OUT21/16837

**Eraring Battery Energy Storage System (SSD-15950052)
Environmental Impact Statement (EIS)**

Liz Rogers
Manager, Assessments, Knowledge Division
Department of Planning, Industry and Environment: Water
9 December 2021

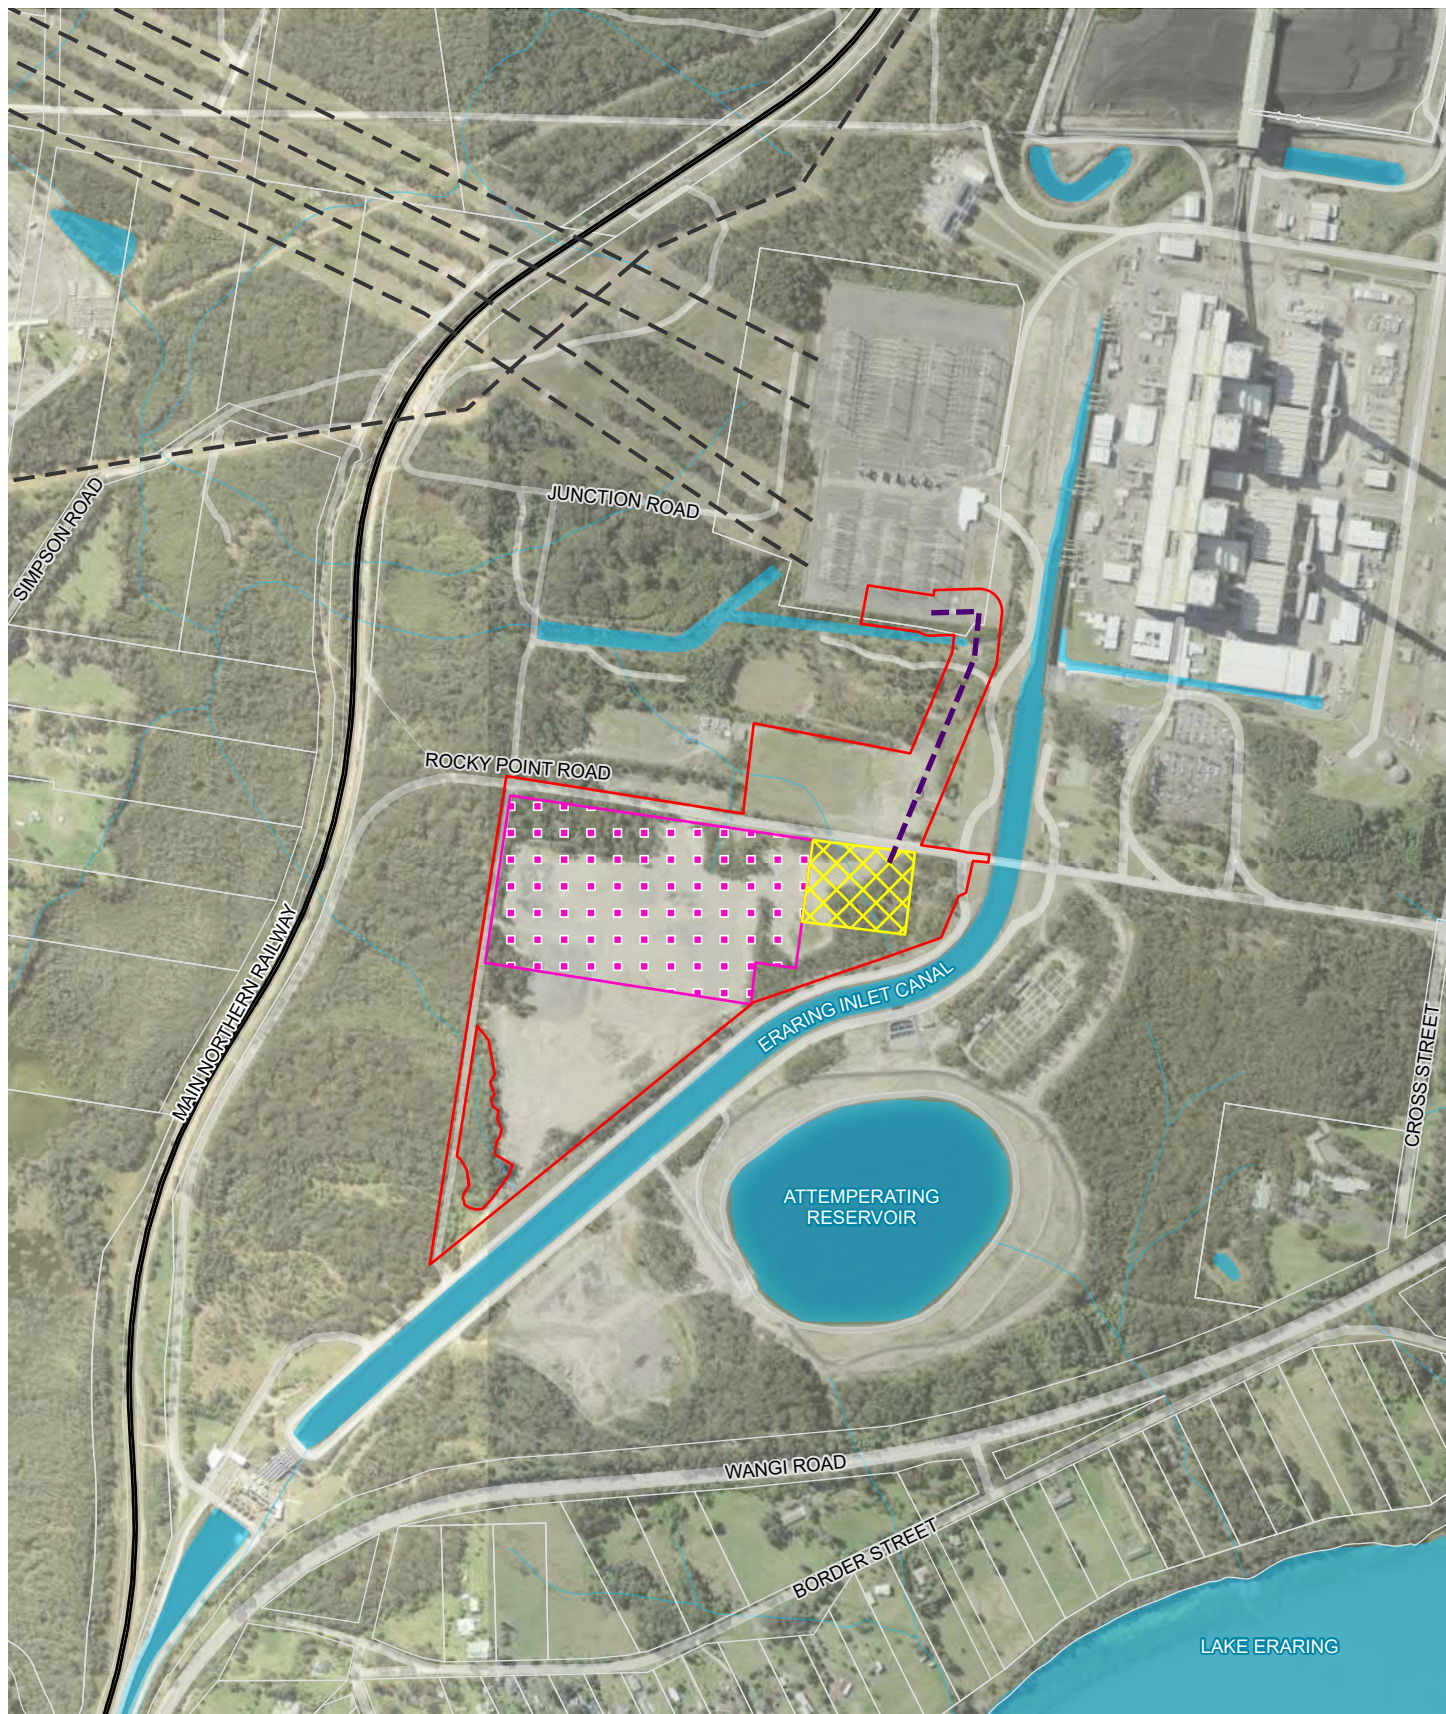
- The proposed substation and battery storage system requires the removal of two mapped first order watercourses. The proponent should provide detail of the characteristics of the riparian corridor in the two first order watercourses that will be removed and an impact assessment to the downstream environment. This is to ensure compliance with the Guidelines for Controlled Activities on Waterfront Land (NRAR 2018) and to determine if any mitigation measures should be put in place.
